Rezoning Transportation Analysis

Petition Number: 2022-210

From: Jake Carpenter, PE
Jacob.carpenter@charlottenc.gov
980-221-5675

Reviewer: Patrick Monroe
Patrick.Monroe@charlottenc.gov
704-301-1411

RZ-03

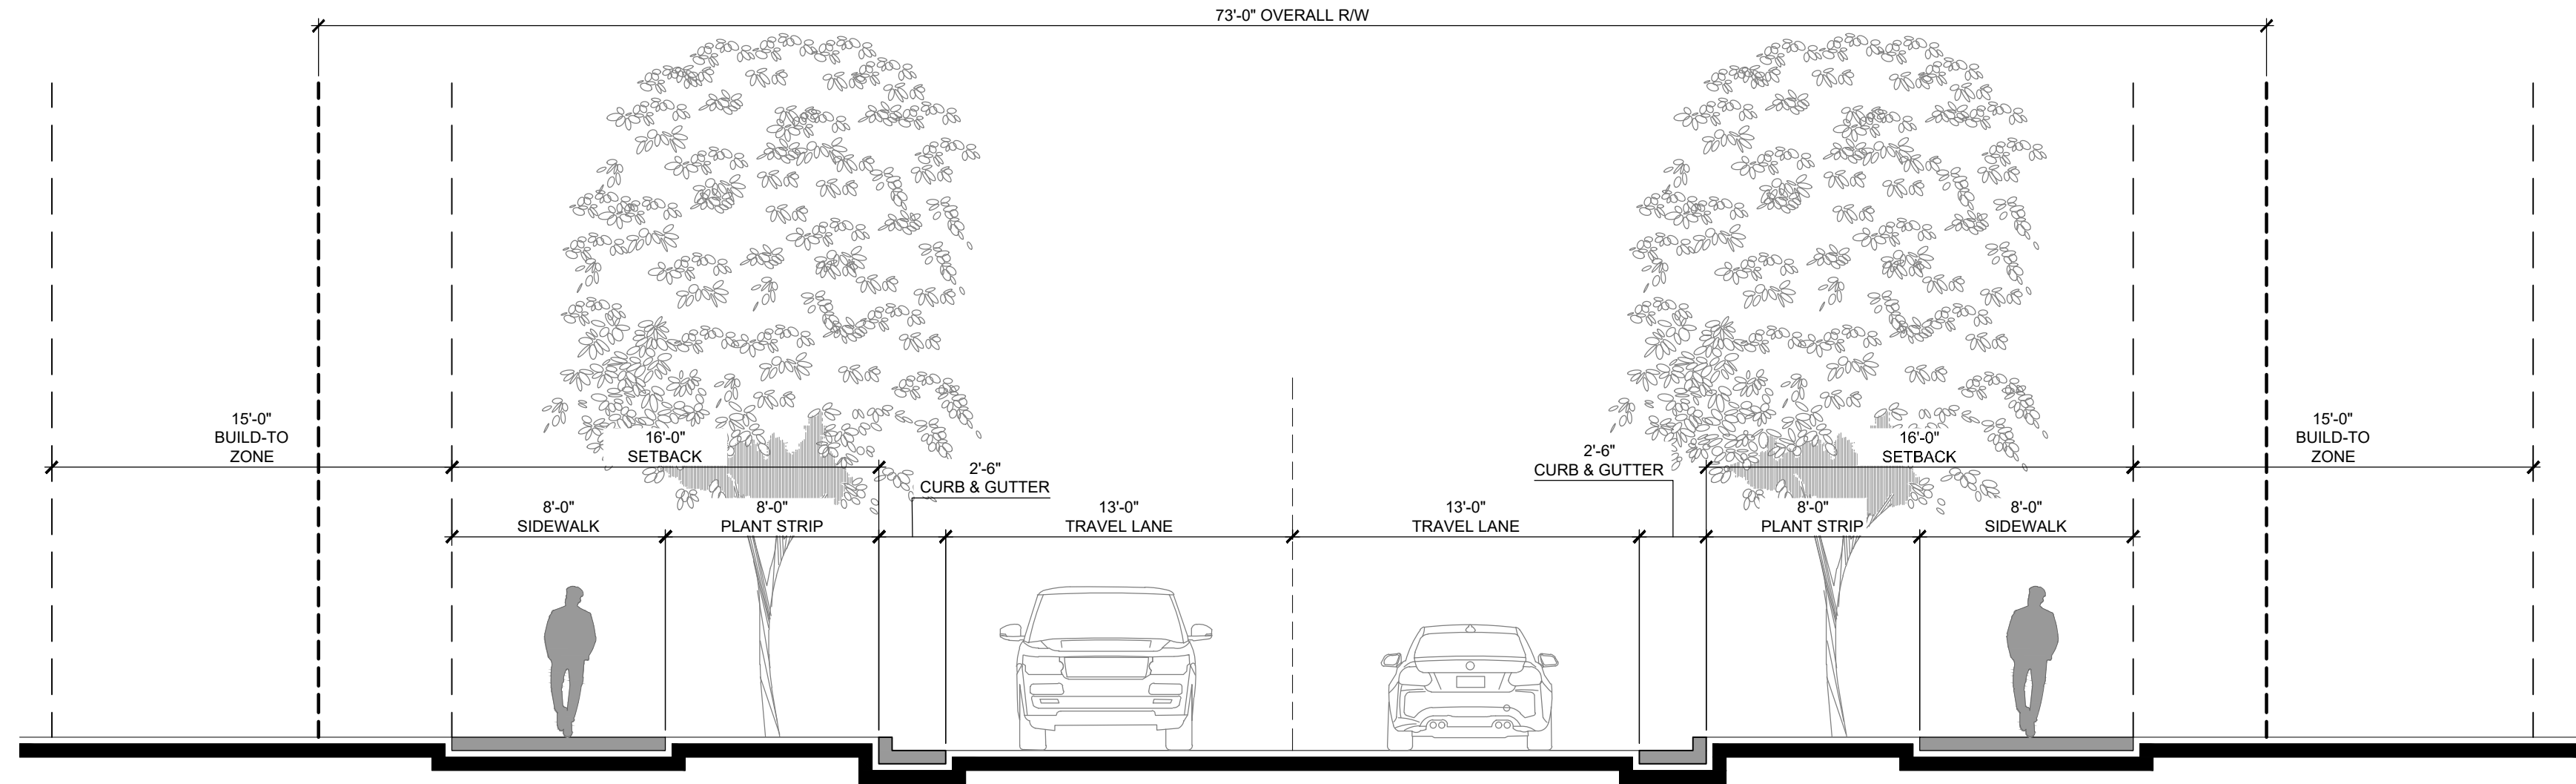
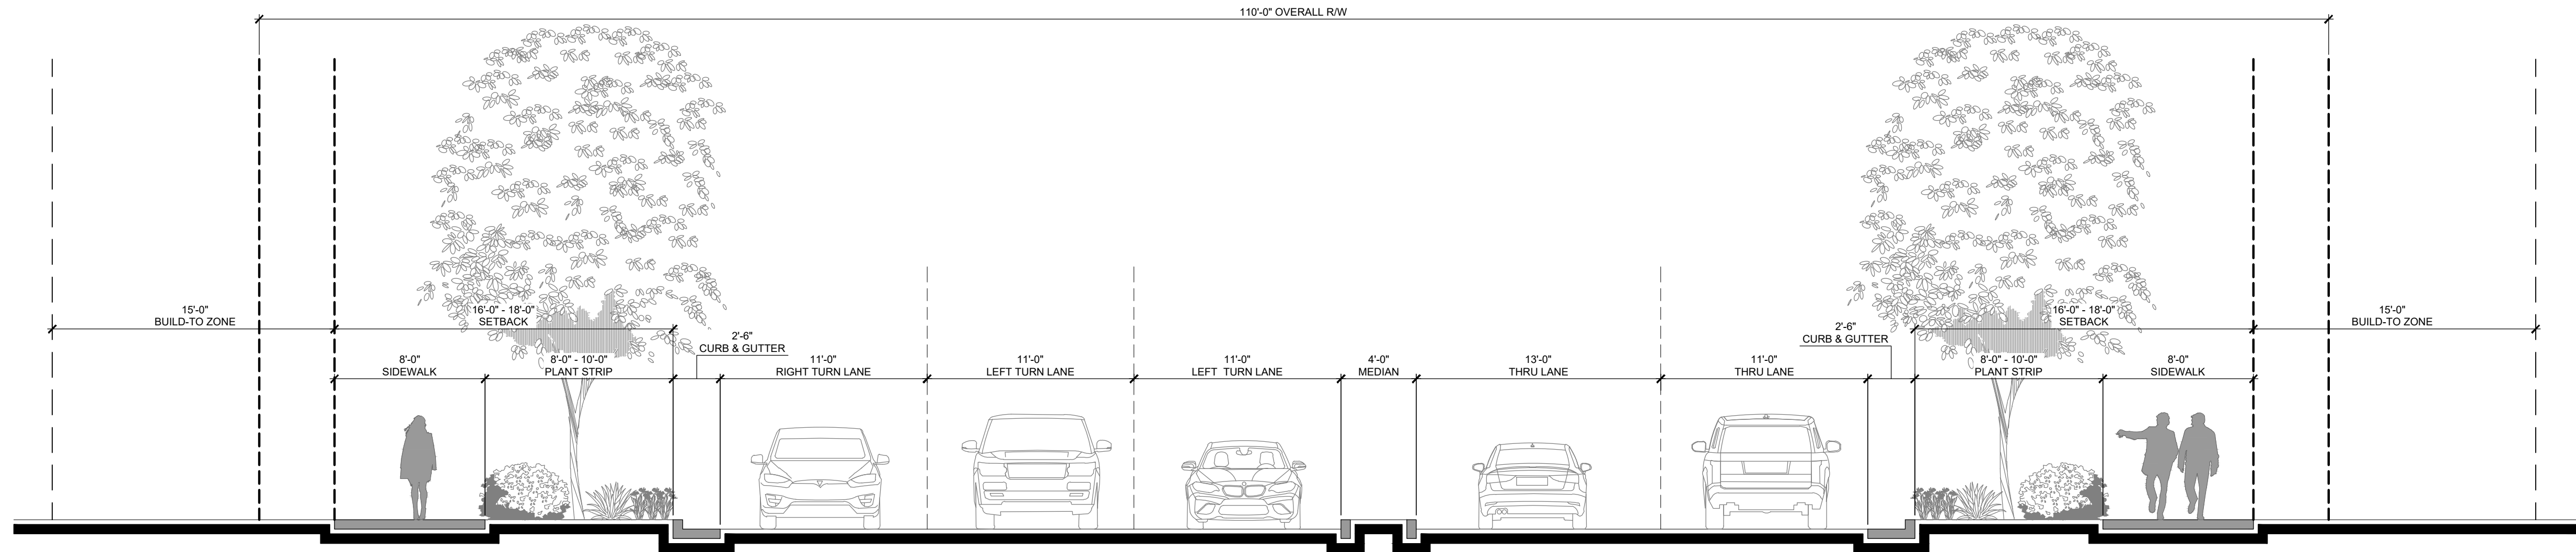
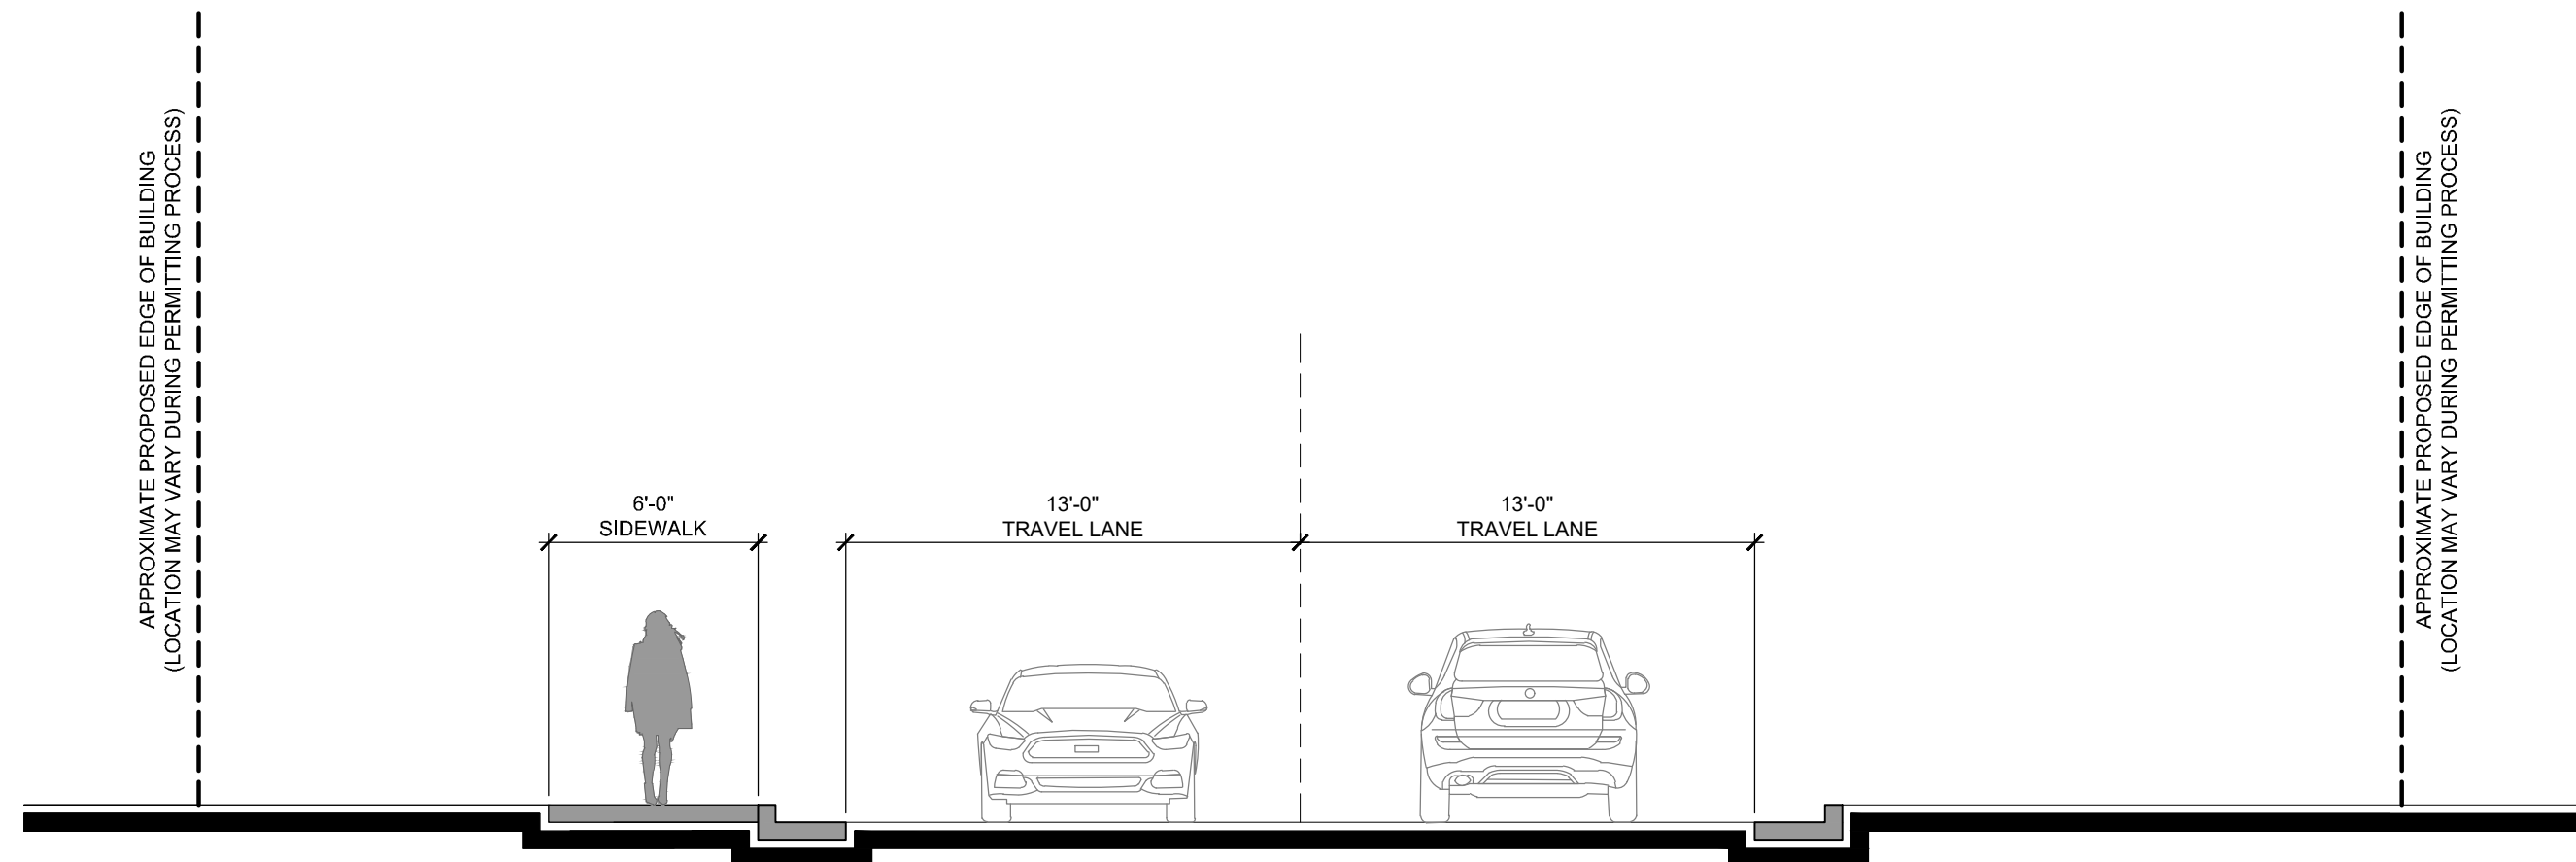
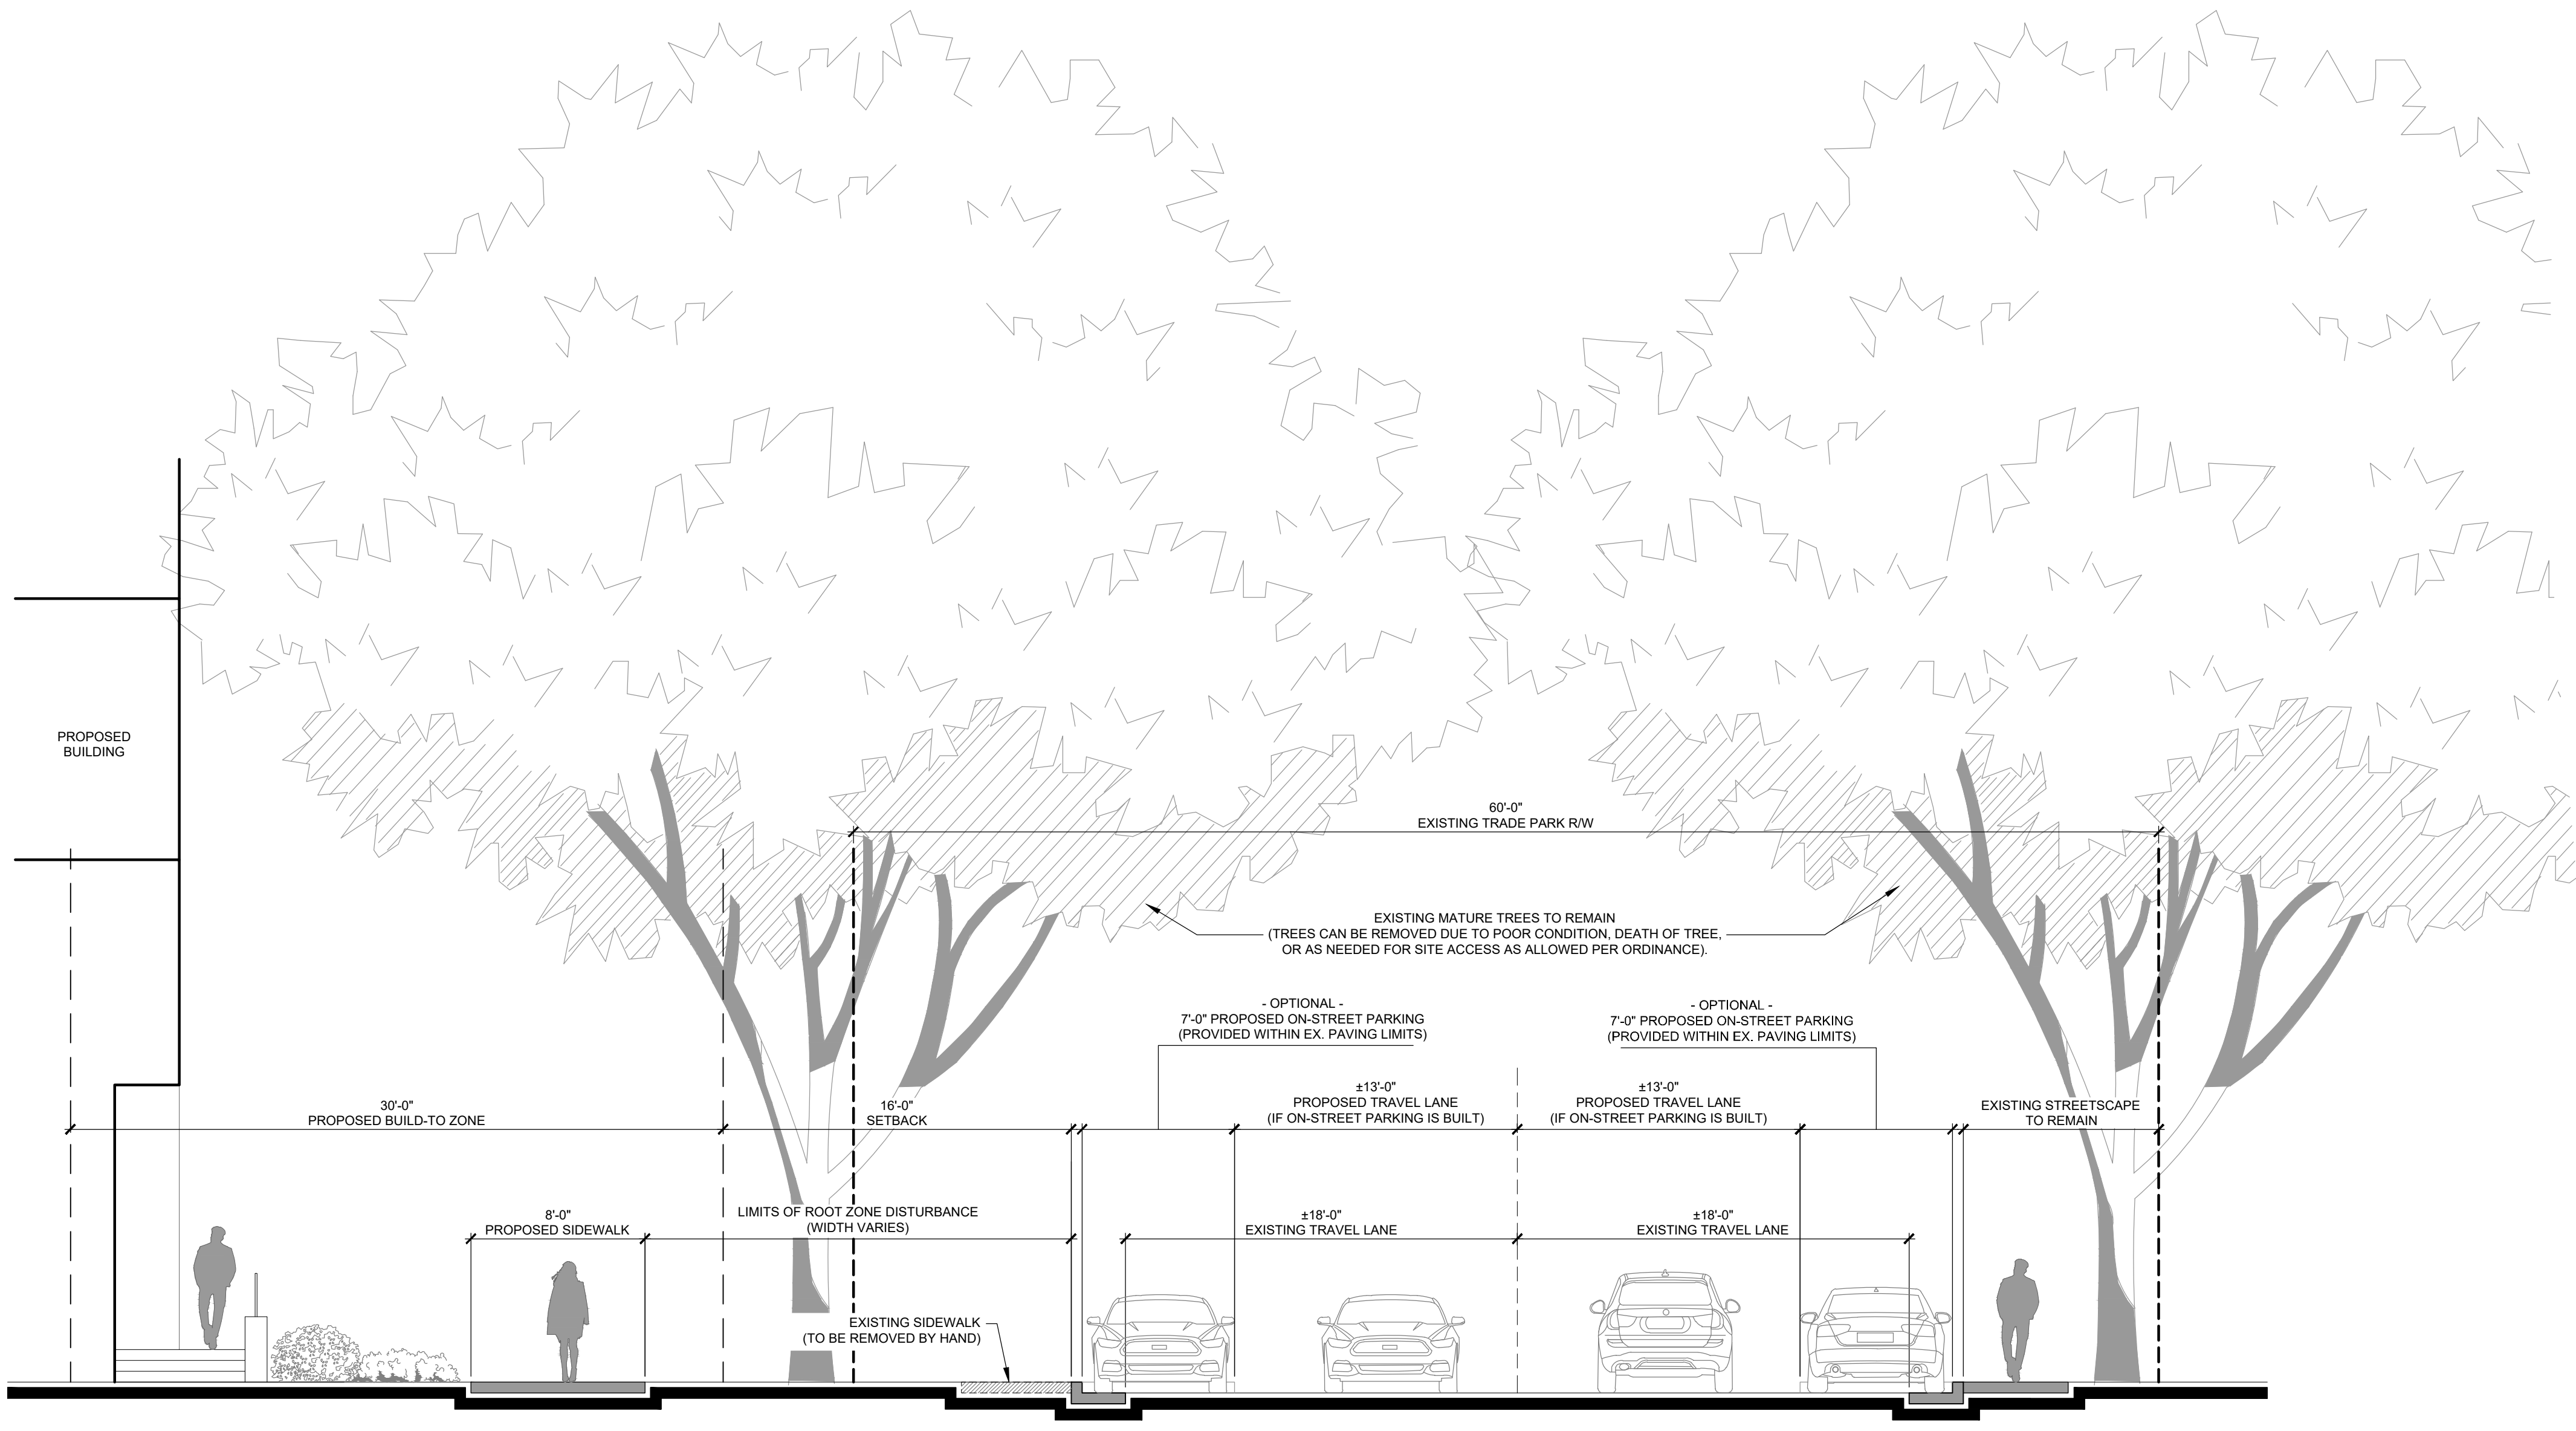
Outstanding Comment 9.20.23: Revise internal street network to standard public street typical sections per the CLDSM or provide additional information on existing constraints for review and approval of nonstandard typical sections.
